State of Washington
DEPARTMENT OF FISH AND WILDLIFE

SUBJECT: WDFW COMMENTS ON SE-22-00059 OWENS ACCESS ROAD

Thank you for the opportunity to comment on the proposed project to build an access road near Bettas Road. The Washington Department of Fish and Wildlife (WDFW) has reviewed the application materials and has the following comments for consideration to ensure adequate protection of all Fish and Wildlife Habitat Conservation Areas.

BETTAS ROAD
DOUG OWENS
EXISTING CONDITIONS/TEC PLAN

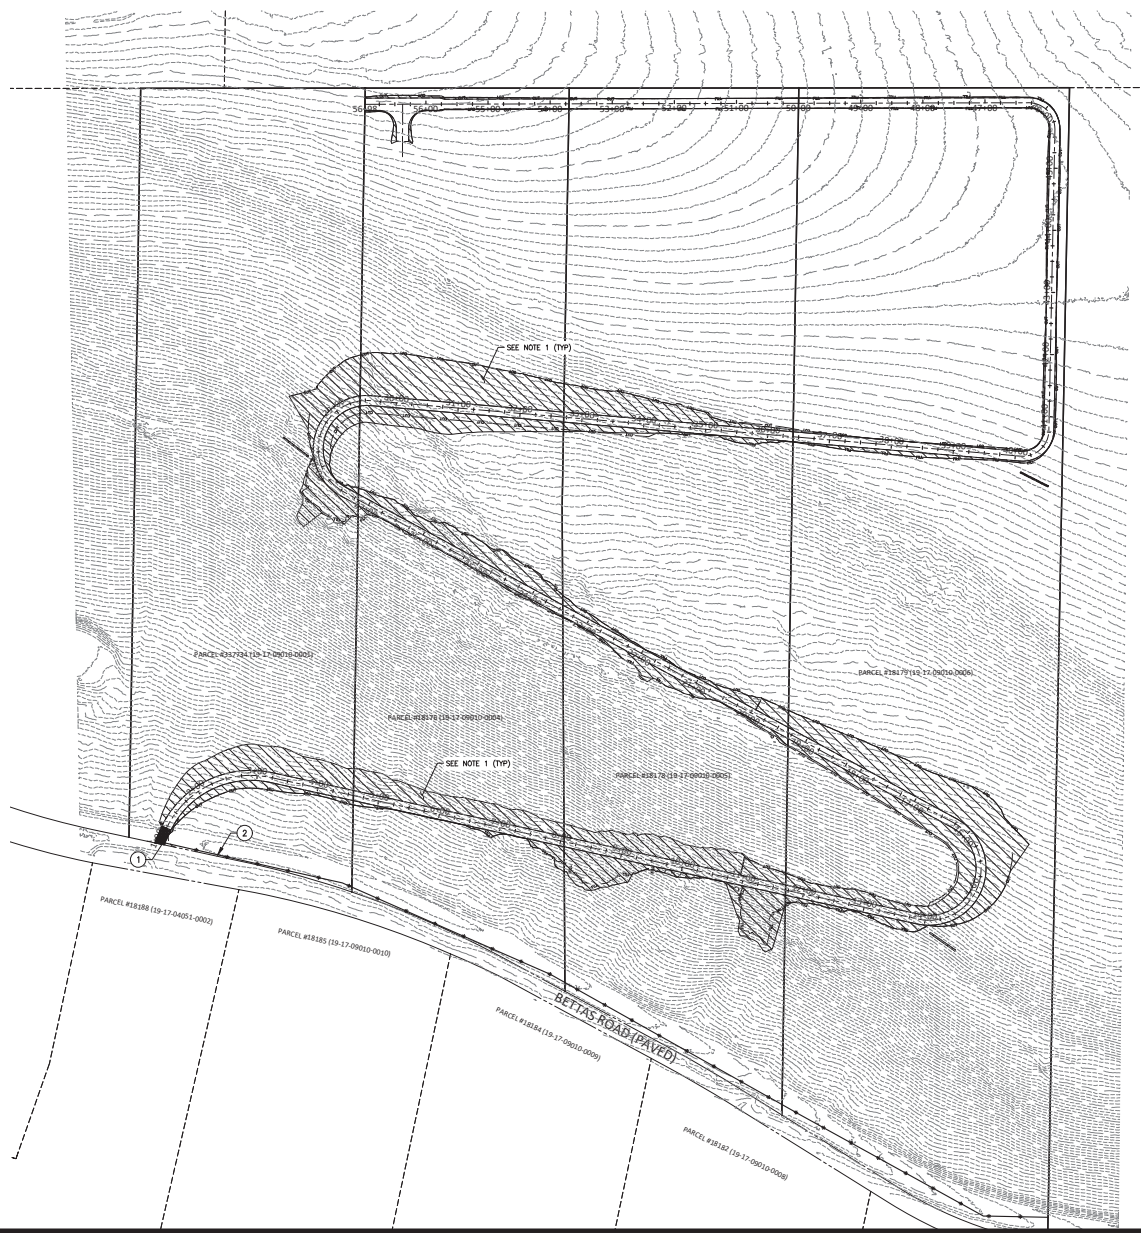
The four parcels within the project area contain shrubsteppe habitat and provide important habitat for mule deer and elk as well as several other birds and reptiles. WDFW's online Priority Habitats and Species (PHS) map has accurately mapped portions of the project area as shrubsteppe habitat, as mule deer winter range habitat, and as a biodiversity area and migration corridor. More information about the PHS species and habitats can be found at this [website](#).

While we appreciate that actions are proposed to minimize impacts, the project as currently proposed will result in a net loss of shrubsteppe habitat and its associated species. The road and subsequent development may also impact migration of animals through this corridor. WDFW recommends mitigation for these impacts. WDFW would welcome the opportunity to meet on site to begin conversations on how best to achieve this mitigation.
